**KIRKLEES METROPOLITAN COUNCIL  
INVESTMENT & REGENERATION SERVICE**

**DELEGATED DECISION FOR DISCHARGE OF CONDITION A.4 -  
NOTIFICATION OF A PROPOSED ENLARGEMENT TO DWELLINGHOUSE**

<b>Reference no.</b>	<b>2025/HH/93213/E</b>
<b>Site Address</b>	<b>1, Lockgate Rise, Birkenshaw, BD11 2PL</b>
<b>Description</b>	<b>Prior notification for single storey rear extension. The extension projects 4m beyond the rear wall of the original dwellinghouse. The maximum height of the extension is 3.4m, the height of the eaves of the extension is 2.8m</b>
<b>Recommending Officer</b>	<b>Joanna Rednall</b>

Drawing Title  
**PROPOSED**

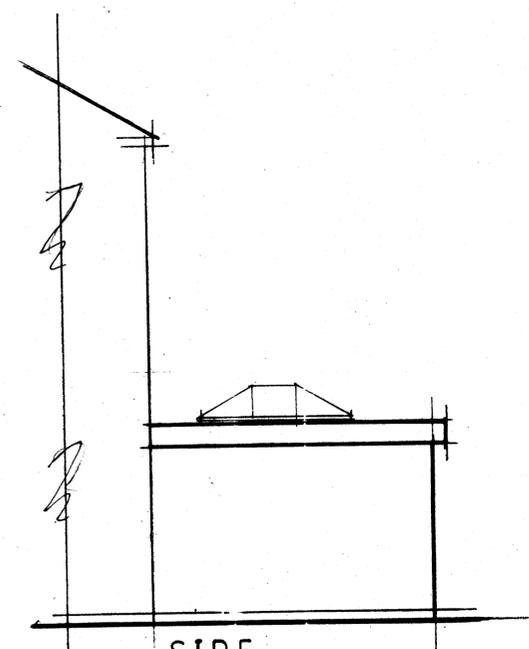
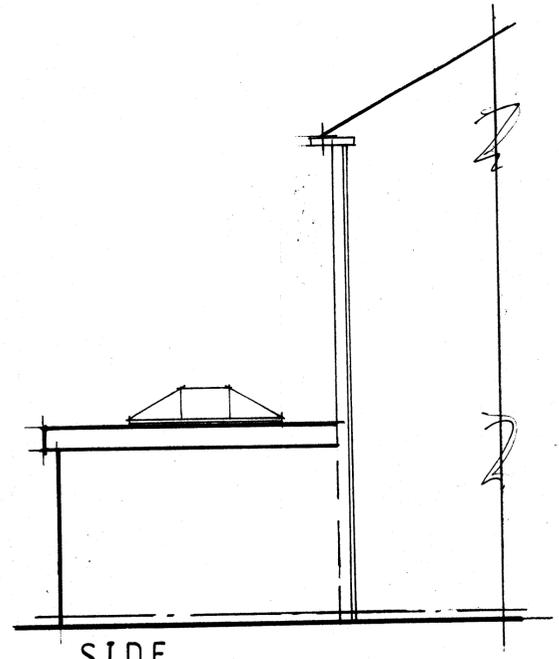
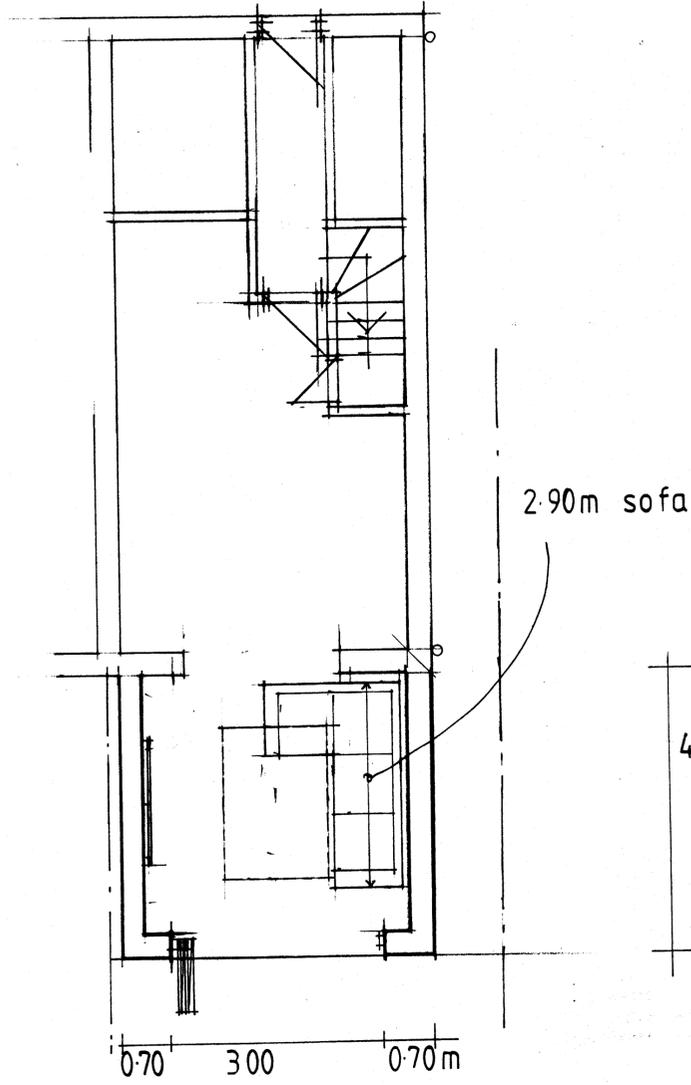
Whilst the rearward projection is relatively short at 1 metre, the scale of the projection is significant at 2.5 metres in height and width. This scale is considered reasonably capable of providing floor space for the dwellinghouse and thus must be considered part of the original dwellinghouse. It follows, therefore that the side elevation of the projection must also be considered as a side elevation of the original dwellinghouse and is of a scale beyond being de-minimis.

Having regard to the Government's householder guide to permitted development rights (2019) and sub-paragraph A.1(j), Class A, Part 1 of Schedule 2 of the Town and Country Planning (General Permitted Development) (England) Order 2015 (as amended) development is not permitted under Class A where the proposed extension extends beyond a side elevation of the original dwellinghouse and has a width greater than half the width of the original dwellinghouse. In this case the submitted plans indicate the proposed extension extends along the whole rear

elevation also projecting from the side of the original rearward projection of the property and is therefore contrary to paragraph (j) of Class A and as such cannot benefit from a permitted development.

The proposed enlargement does not benefit from a general planning permission under Article 3(1) and Class A, Part 1 of Schedule 2 of the Town and Country Planning (General Permitted Development) (England) Order 2015 as the rear projection extends beyond a wall forming a side wall of the original dwellinghouse and has a width greater than half the width of the original dwellinghouse contrary to sub-paragraph A.1(j) of Class A.
